PROJECT # 1003125 APPLICATION # 07-70192

**RE: Tract D-1 & S-1, Lands of Double Eagle II Airport aerospace
Technology Park/p &f**

DEVELOPMENT REVIEW BOARD – SPEED MEMO

DRB CASE NO: 1003125

ADA PARKING AREA DETAIL
 SCALE: 1"=10'

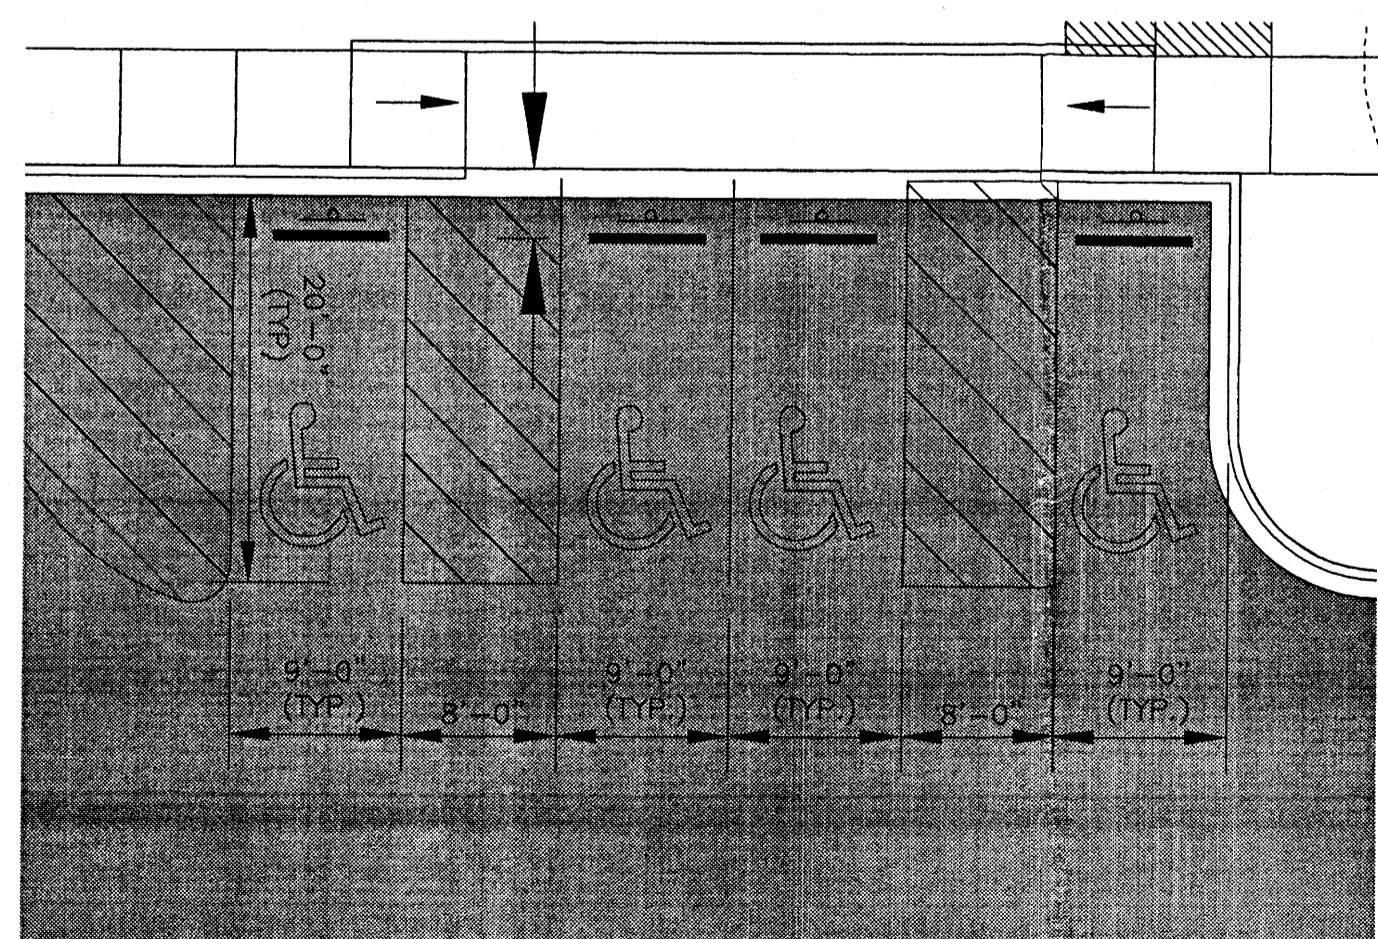
Call out the width of all handicapped parking spaces and associated aisles.
Clarify existing versus proposed conditions. Infrastructure may be required for this site.
How does the site access a public roadway? Provide additional information.
Infrastructure list: where are these items located? Additional information is needed.
